CITY OF ALBUQUERQUE

April 29, 2009

**Re: APS Prototype Elementary School No. 2 Grading and Drainage Plan
Engineer's Stamp dated 4-17-09 (B10/D004A)**

GRADING & DRAINAGE PLAN

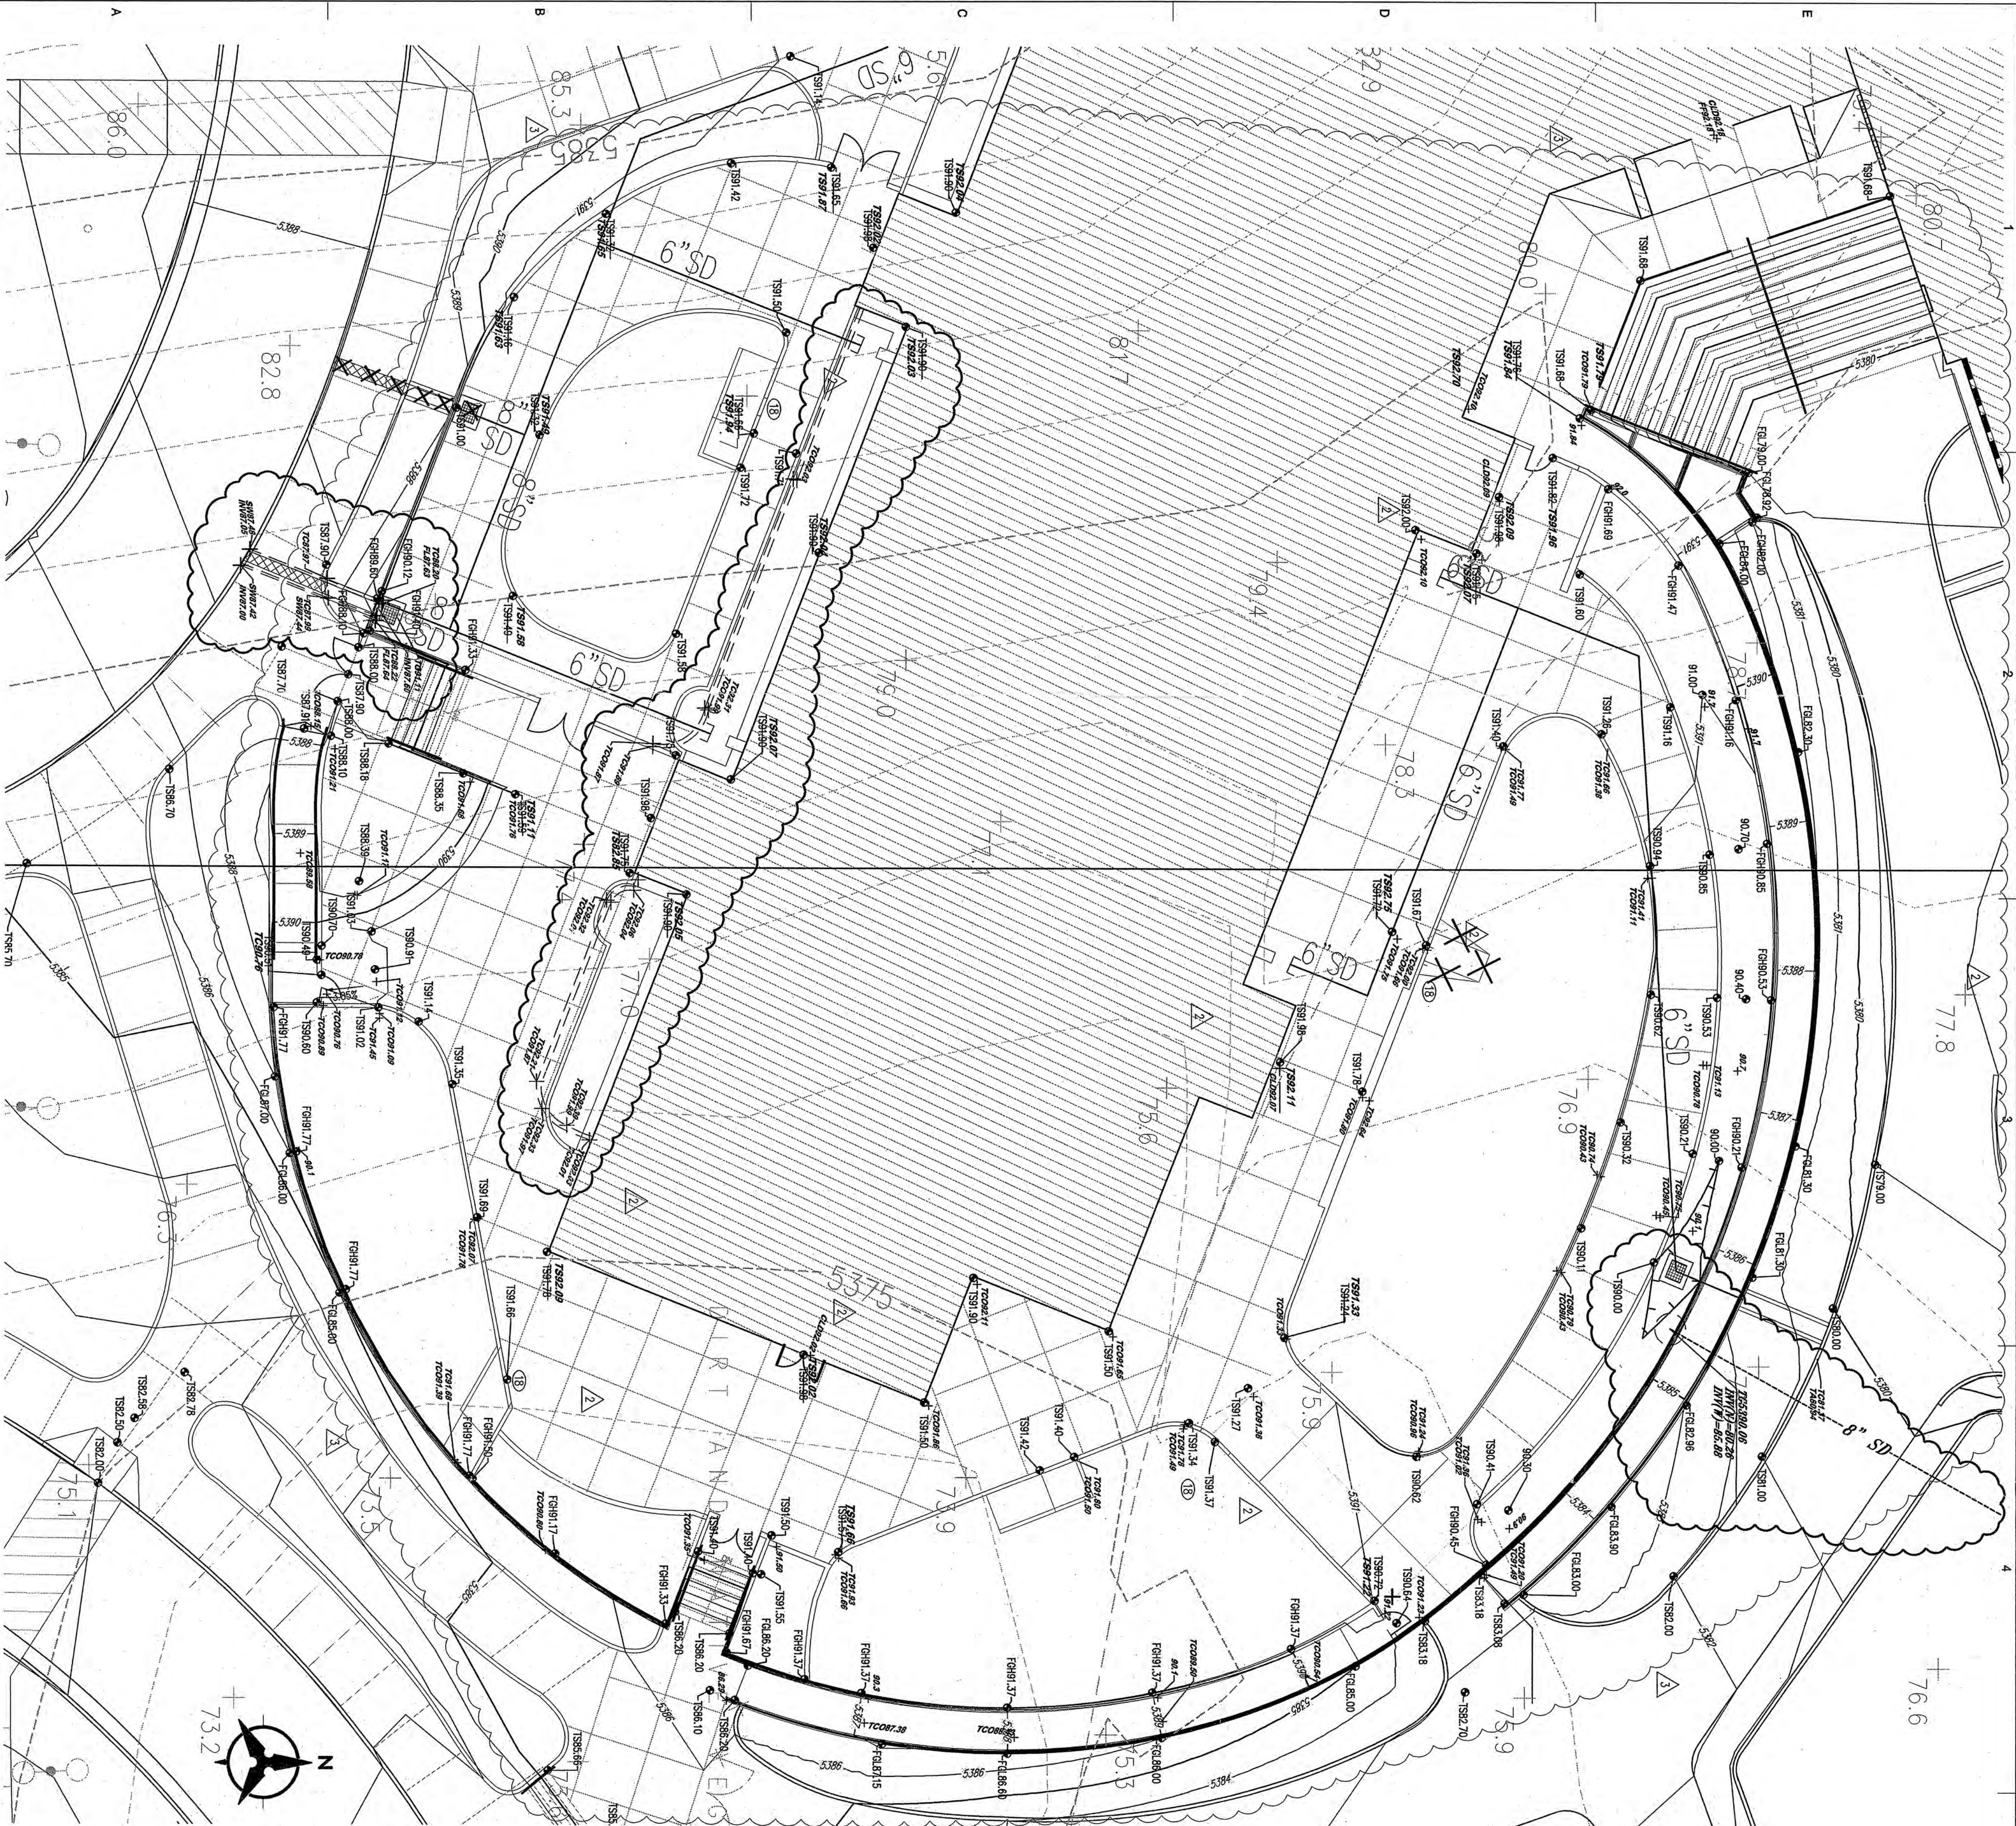
The invert of the 18" storm drain at the inlet in the access road was proposed at 62.5. On the infrastructure plans that built the inlet, the invert in was supposed to be 64.0 and the invert out is at 63.15. When certifying the site for Permanent CO, update the invert elevation, and slope of the storm drain, the water surface elevation and location of the ponding area, if a ponding area will exist, due to the reduced capacity of the storm drain.
